Hinckley National Rail Freight Interchange Application

7th February 2025

As the Members of Parliament representing the constituencies directly affected by this proposal, we write regarding the proposed Hinckley National Rail Freight Interchange (HNRFI) development. We make this submission in response to the invitation by the Secretary of State to respond to the additional submissions in respect of the application made by Tritax Symmetry (“the Applicant”) published in December 2024.

**WORK No.7 A47 LINK ROAD ACOUSTIC FENCE LOCATION GABION WALL OPTION**

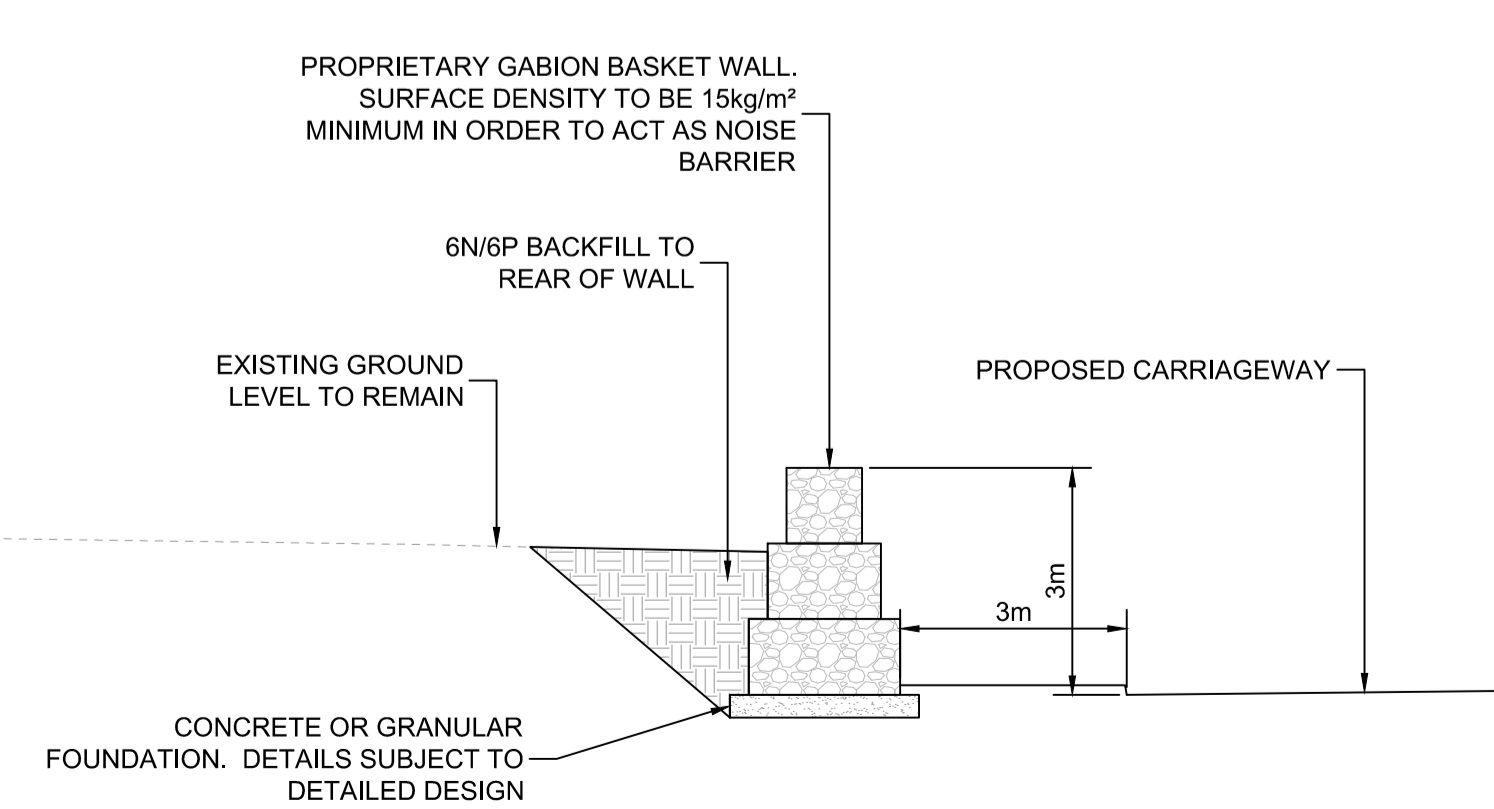
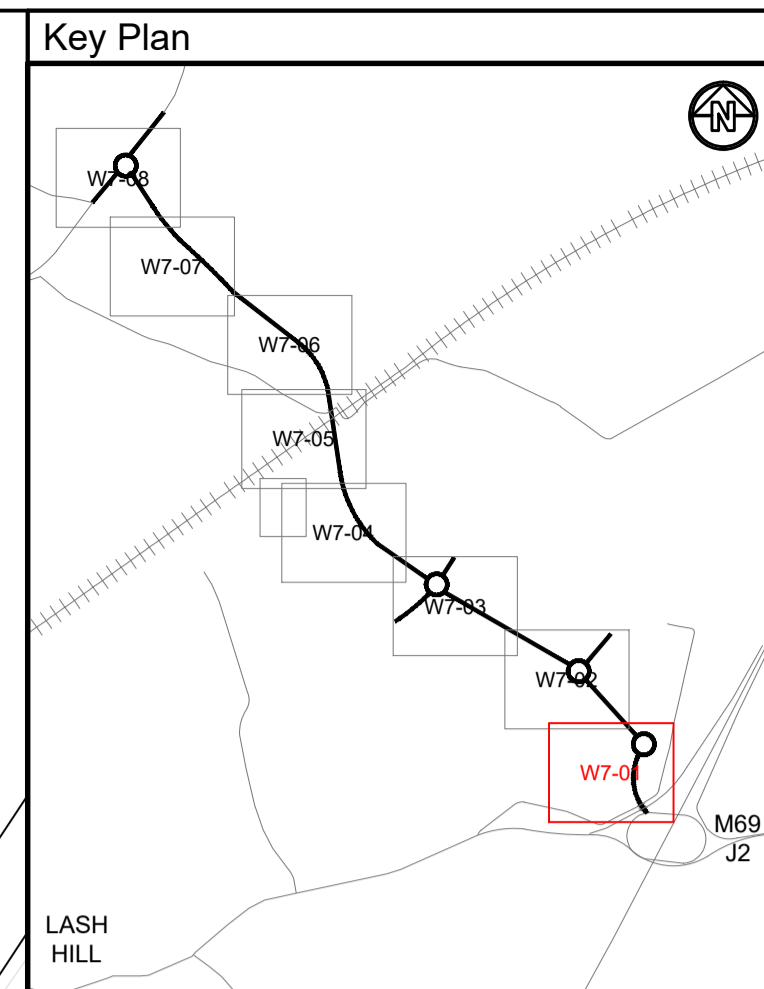
In response to the ExA's concerns, the Applicant has proposed modifications to the acoustic barrier, including relocating the fence to create a 12-meter buffer between the fence and Aston Firs, reducing its height to a maximum of 3 meters, and replacing it with a gabion wall.

While we agree that a gabion wall is aesthetically preferable, the proposed barrier will still be visually oppressive for Aston Firs residents and unattractive from beyond the fence. Additionally, the removal of existing trees and hedges for the fence's construction has not been adequately addressed.
